CITY OF ALBUQUERQUE

PLANNING DEPARTMENT – Development Review Services

RE: Indian Cycle Dealer, 4508 Alameda Blvd. NE
Grading & Drainage Plan For Grading and Paving Permit
Engineer's Stamp Date 4-30-2014 (File: C17D002A22)

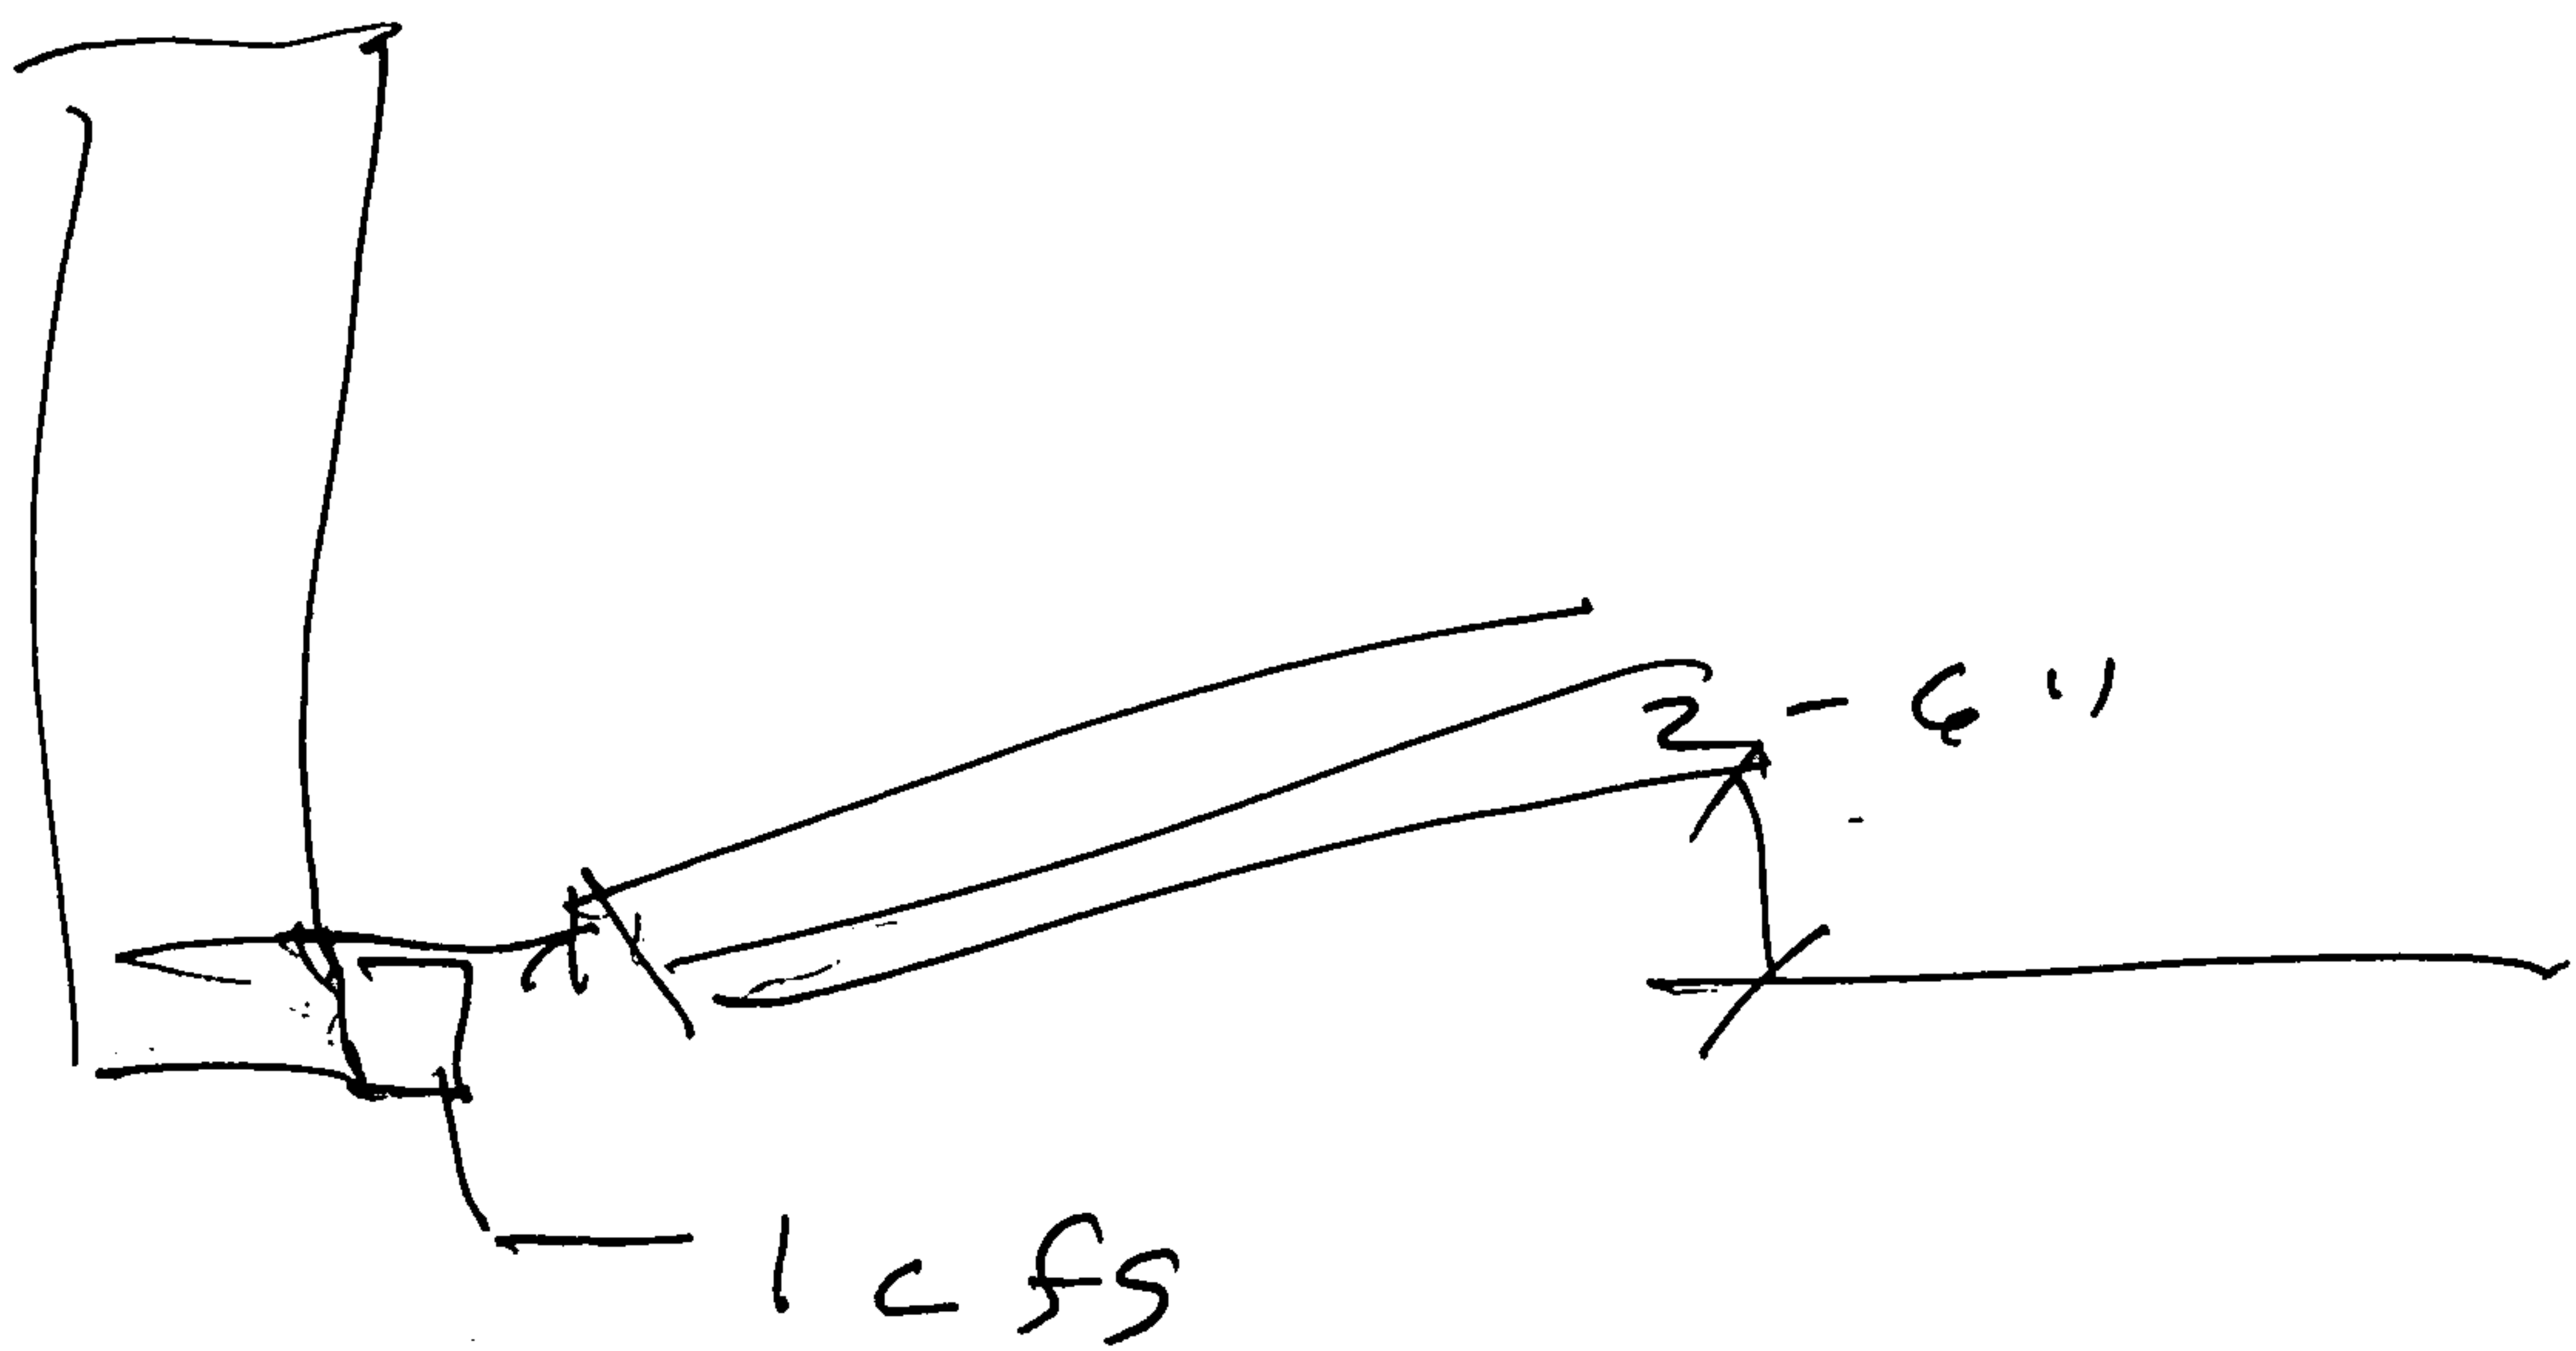
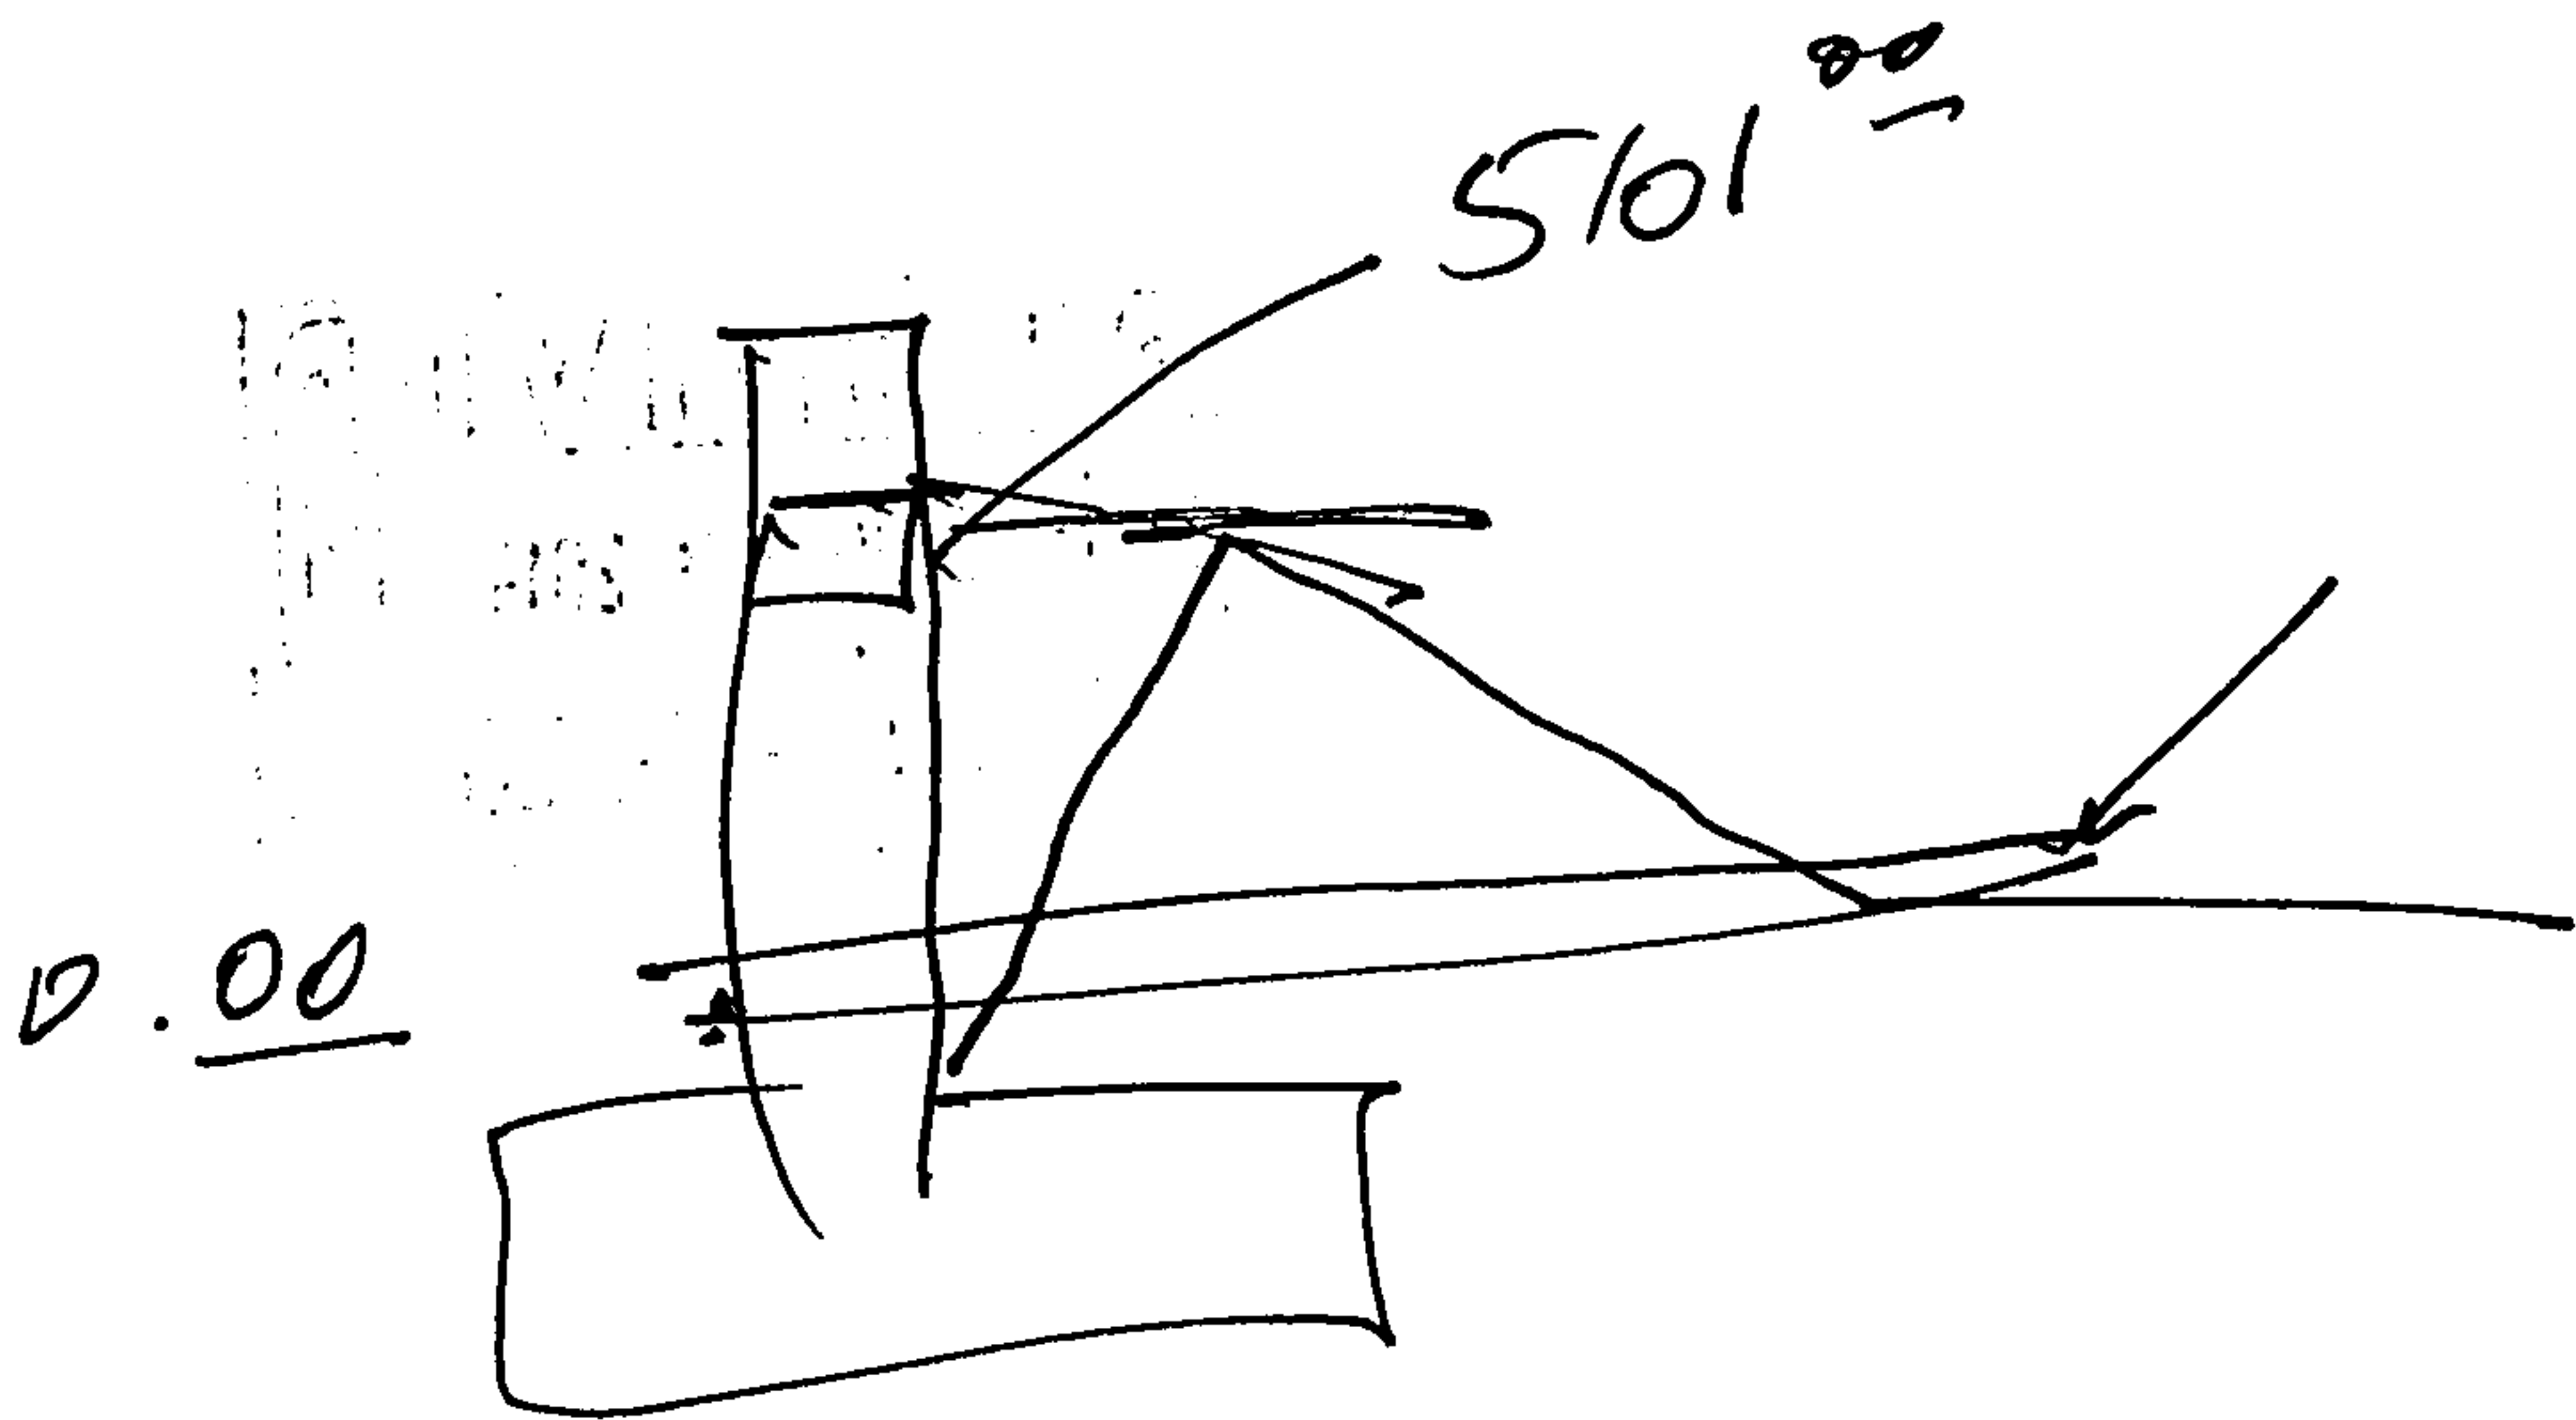
- Calculations indicate that the runoff volume is 6625 CF and that the allowed discharge is 2.10 CFS, but there are no calculations or hydrograph showing how the required pond volume is determined.
- Show calculations showing how the proposed discharge is limited to the allowed discharge of 2.1 CFS. Is the Concrete Rundown Section shown the "New PCC Rectangular Discharge Weir"? If so, please reference detail.
- Pond Contour lines are unclear at the rim. What are the elevations at the corners of the Top of Pond.
- Indicate in the narrative that the site is adjacent to an AO flood zone in Alameda.
- Indicate in the narrative that the outflow of the detention pond is to an existing drainage swale.
- West side of site has an existing rundown that appears to be removed. How will flow be diverted to pond?
- Curb cuts are not clearly shown. Break lines in the curb would make it clearer.
